Department of Planning, Industry & Environment
GPO Box 39
Sydney NSW 2001

Application No: SSD-10831778

Re: Randwick City Council submission on the State Significant Development SSD-10831778 – Sydney Children’s Hospital Stage 1 and Children’s Comprehensive Campus Centre (SSD-10831778)

5 PROPOSED HOURLY SHADOWS - JUNE 21 - 12 PM
1 : 1500

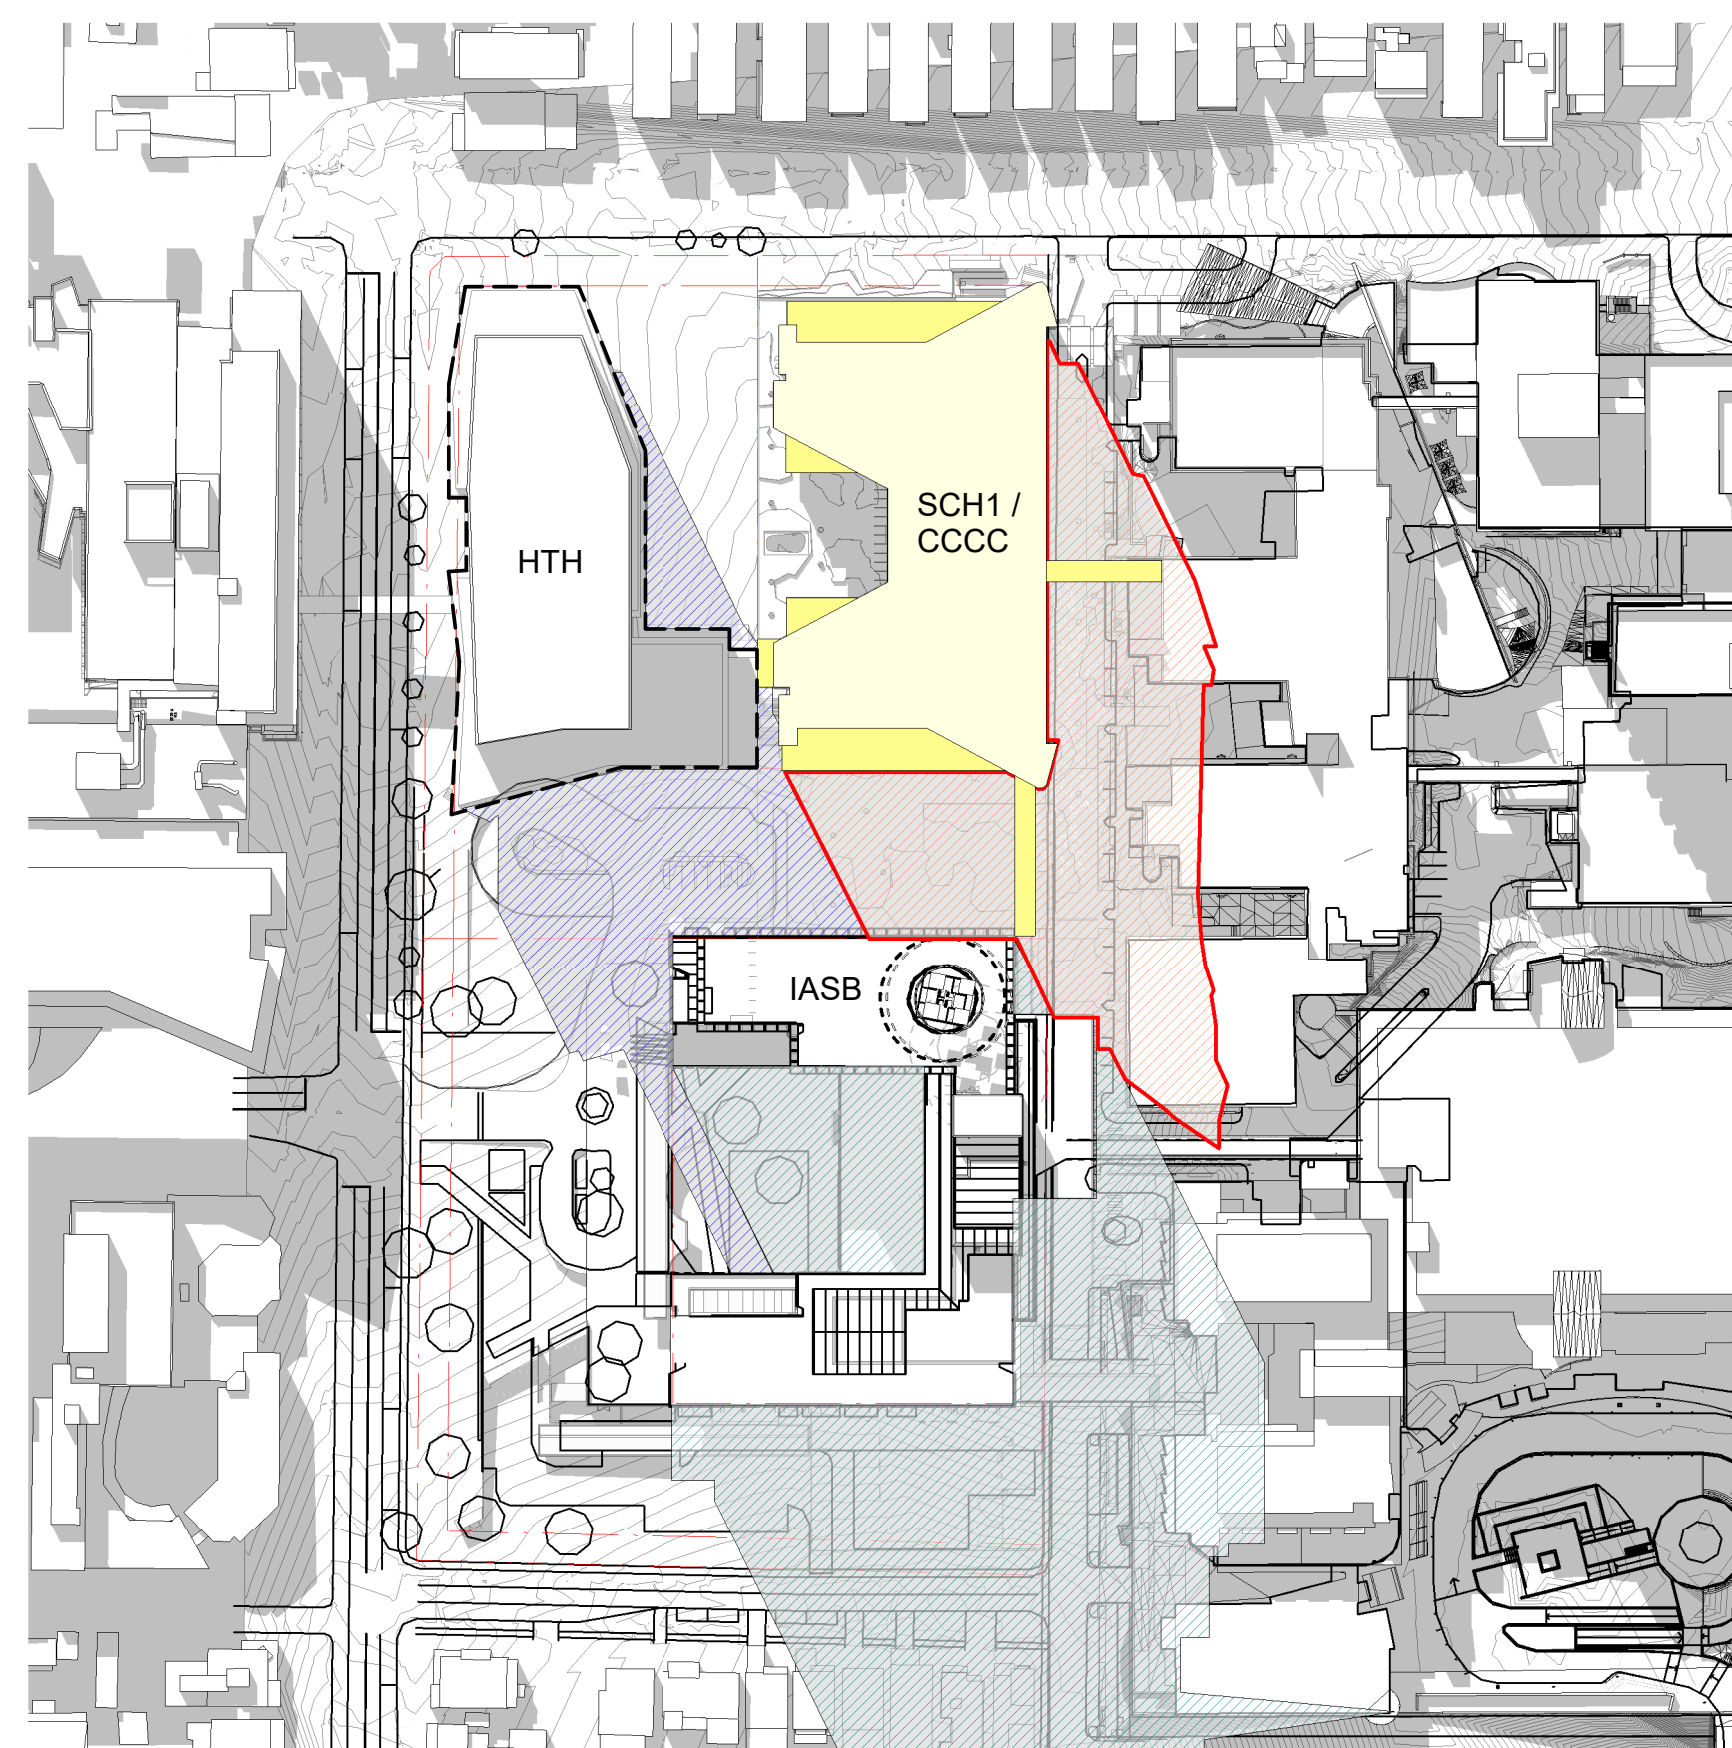
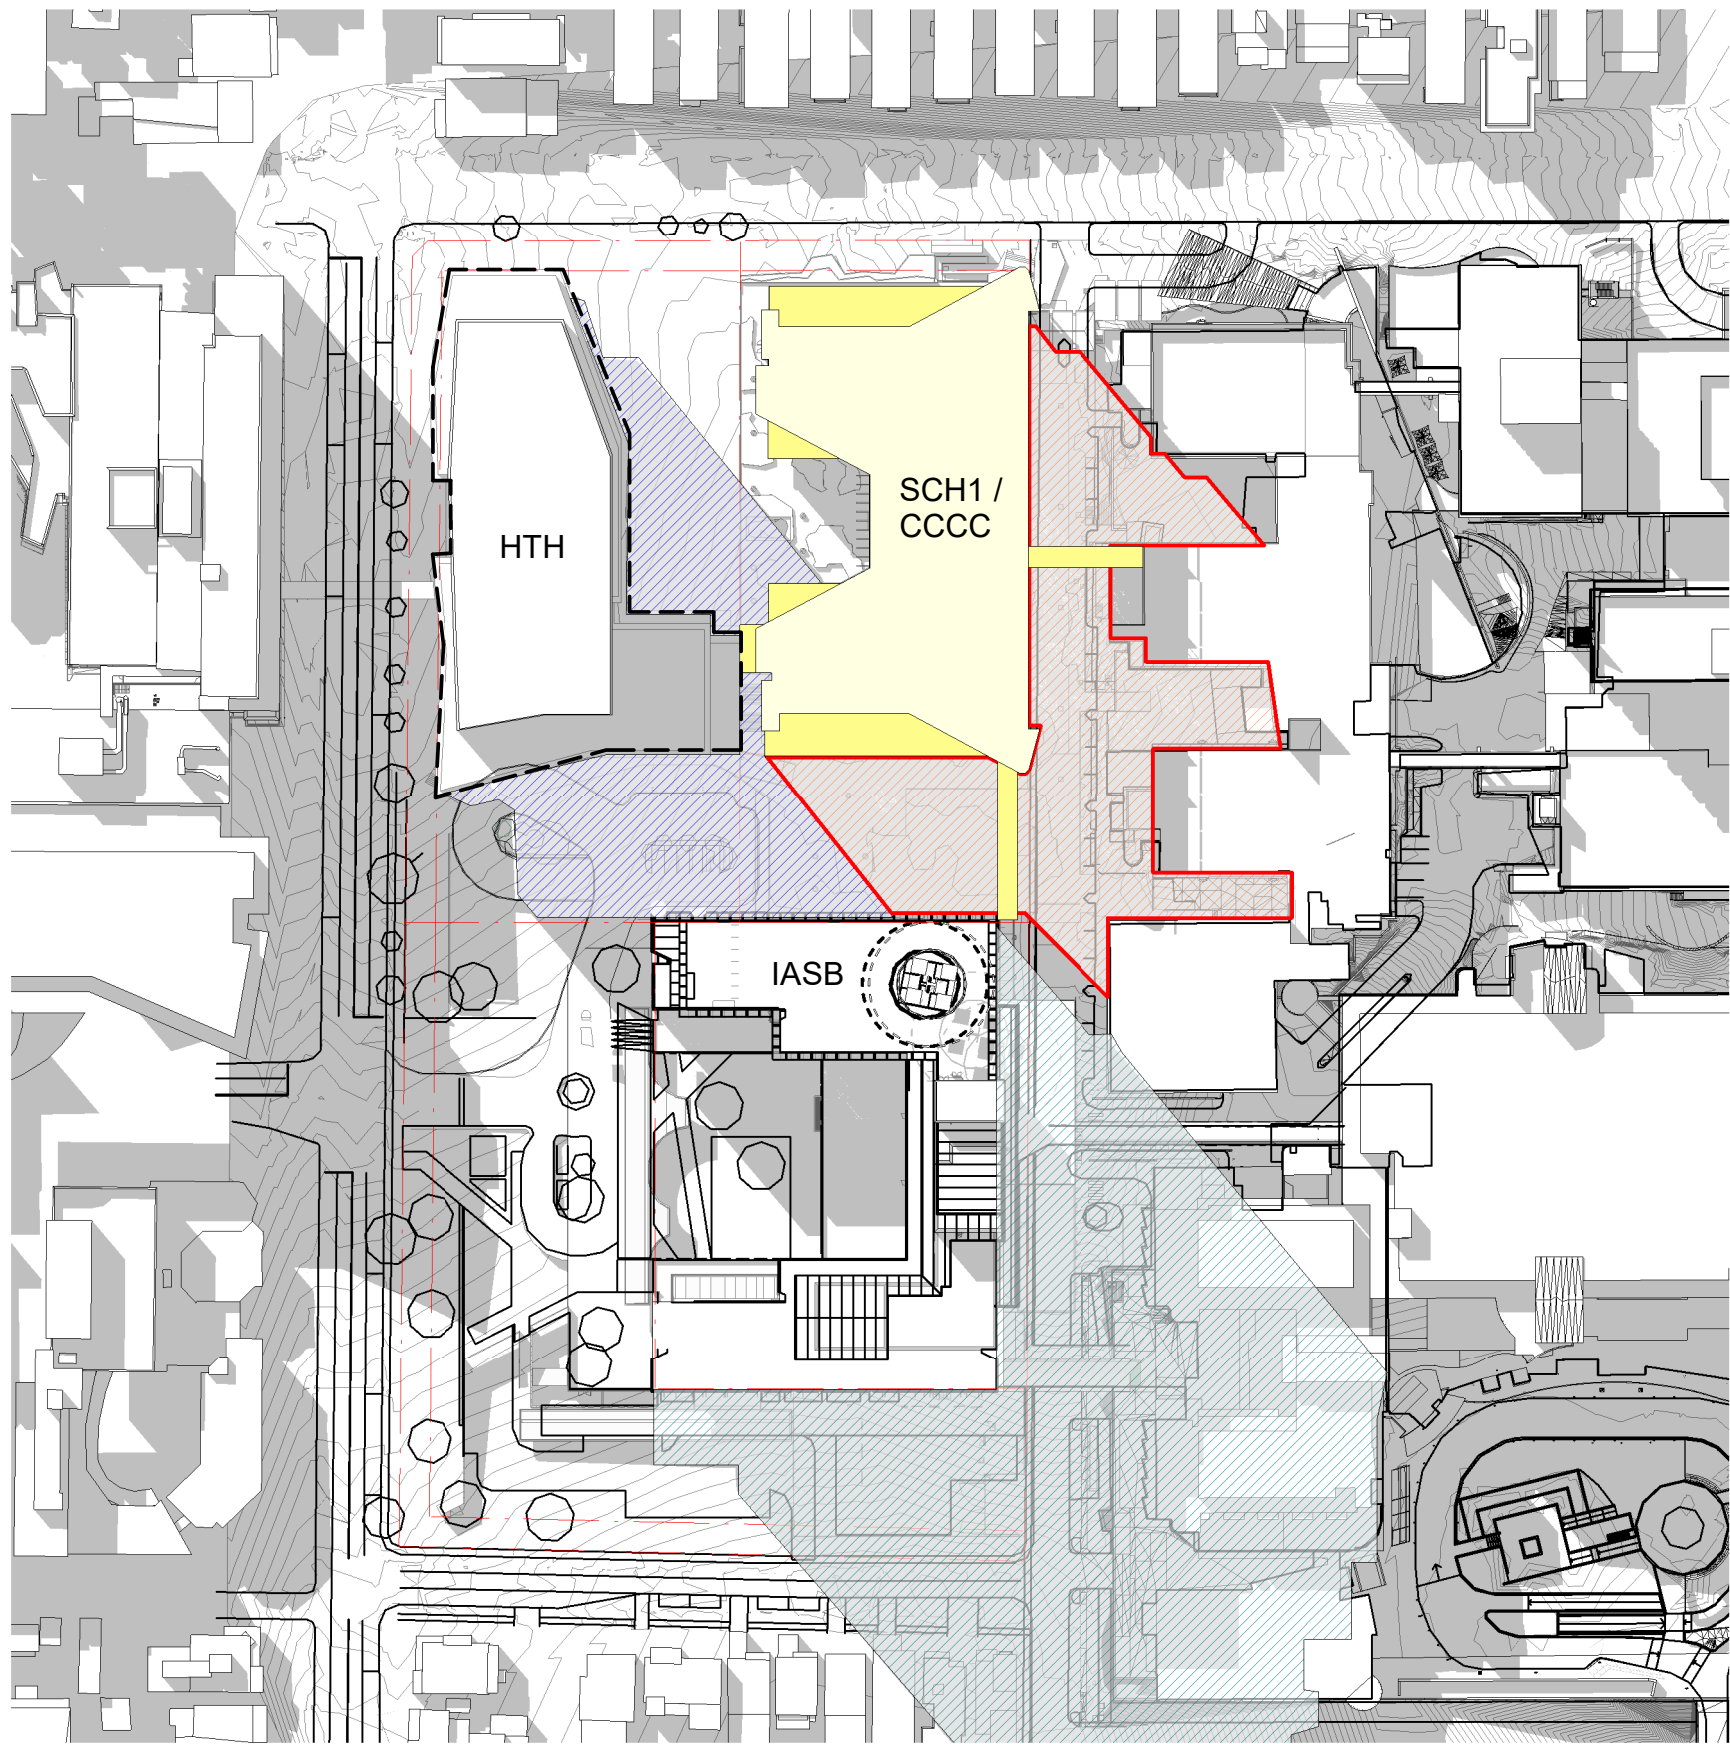
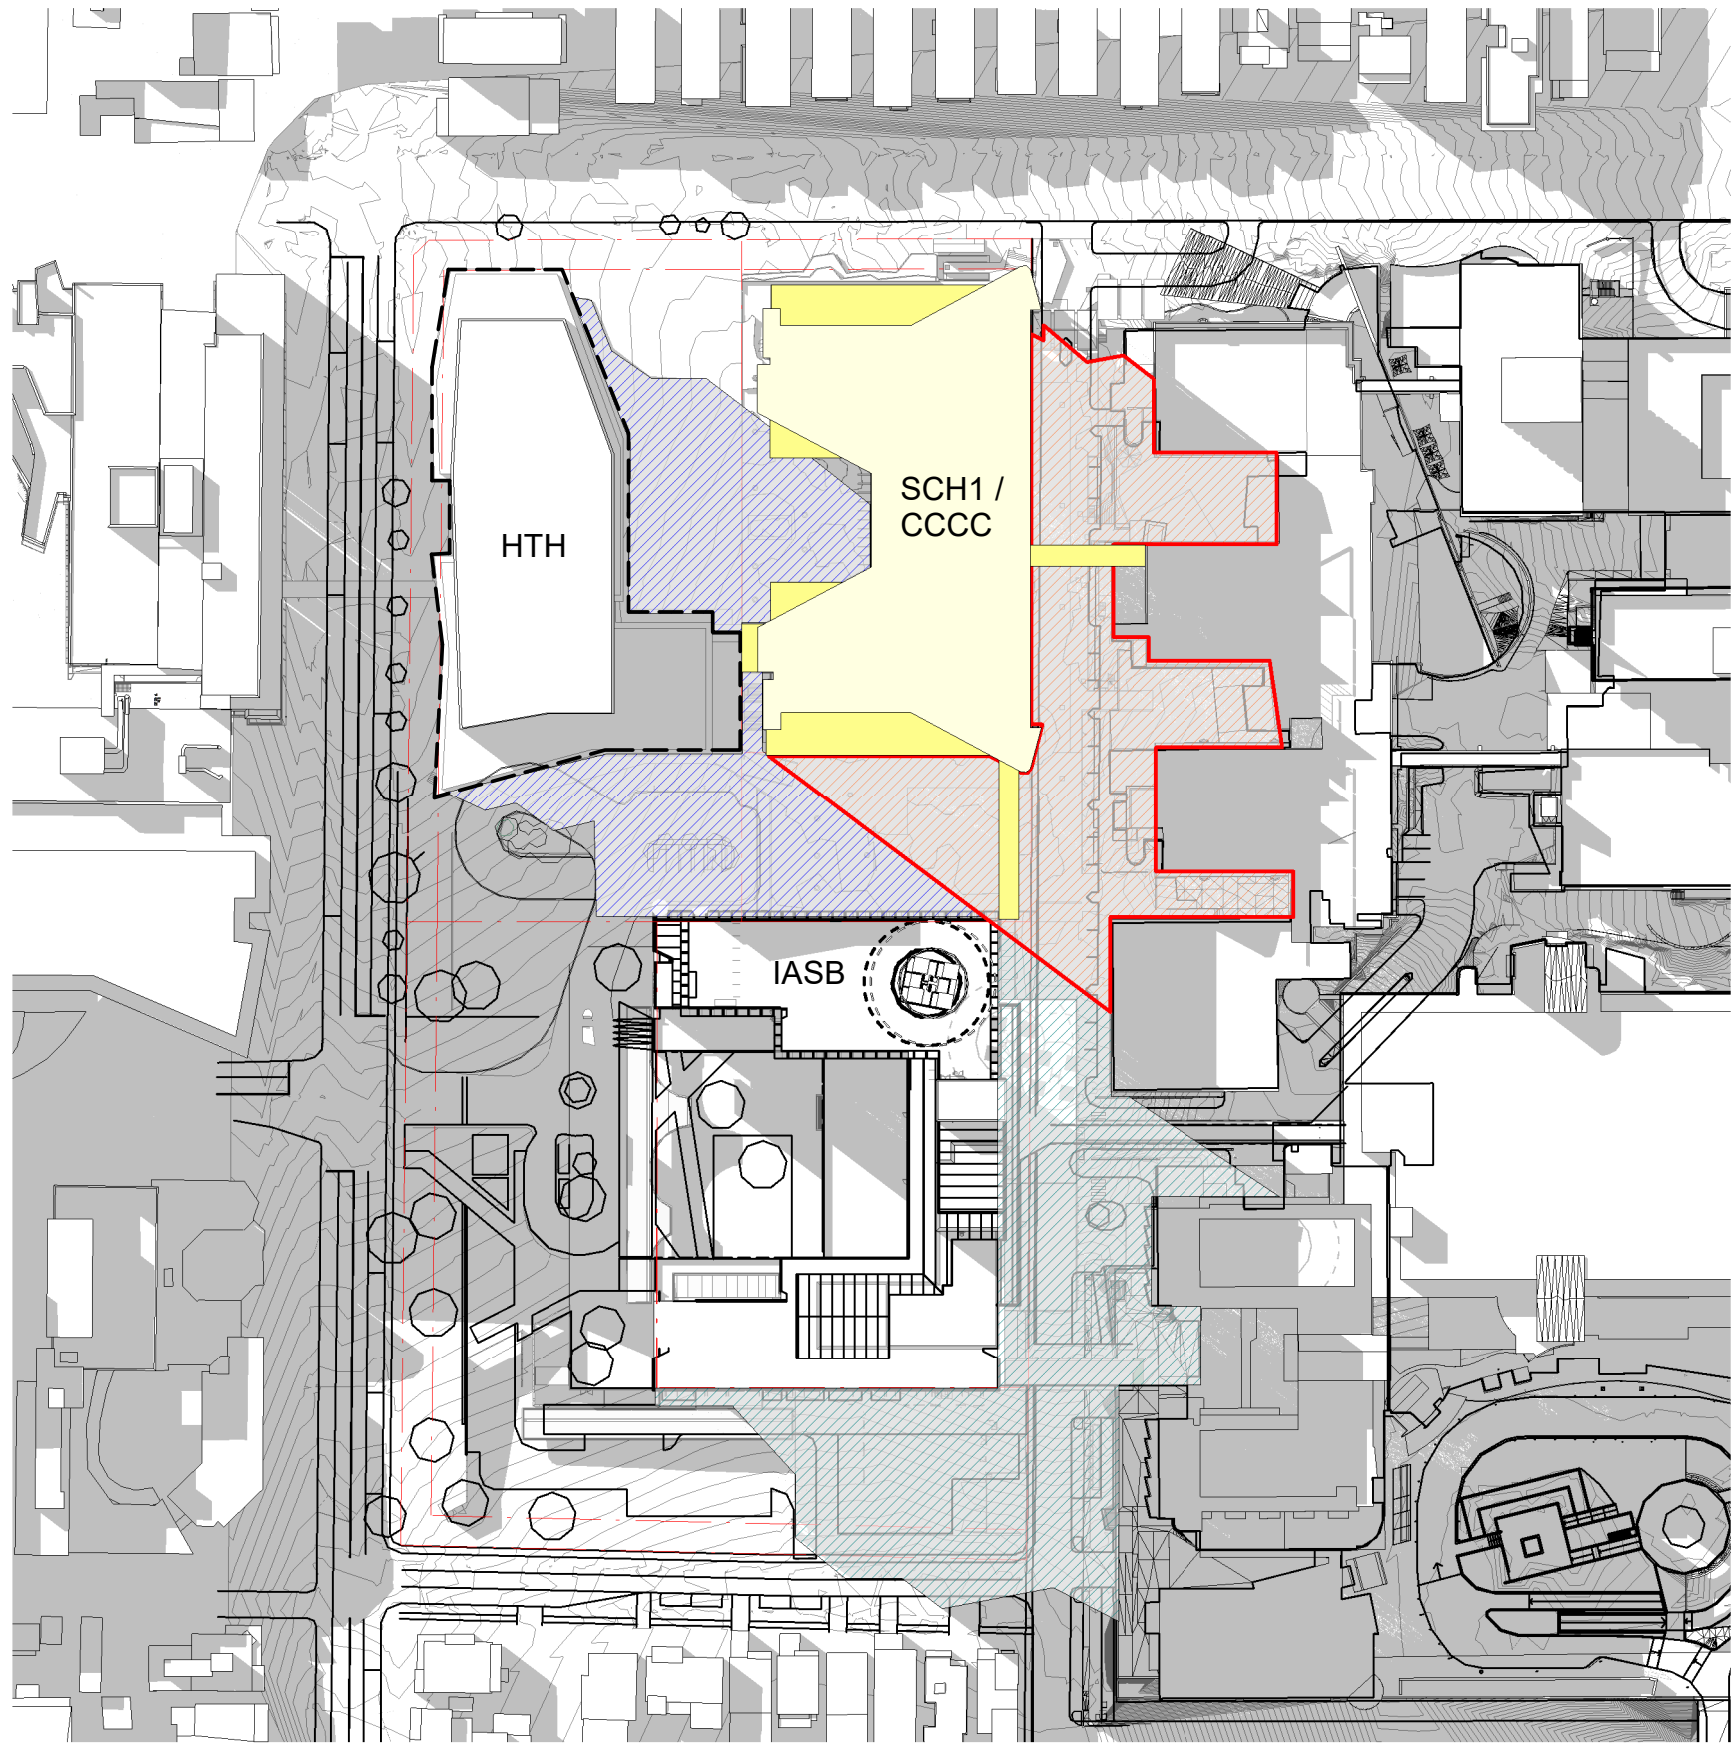
30. Shadow studies should be provided at hourly intervals for the winter solstice to assess solar access to the key public domain areas such as the plaza and children's play area.
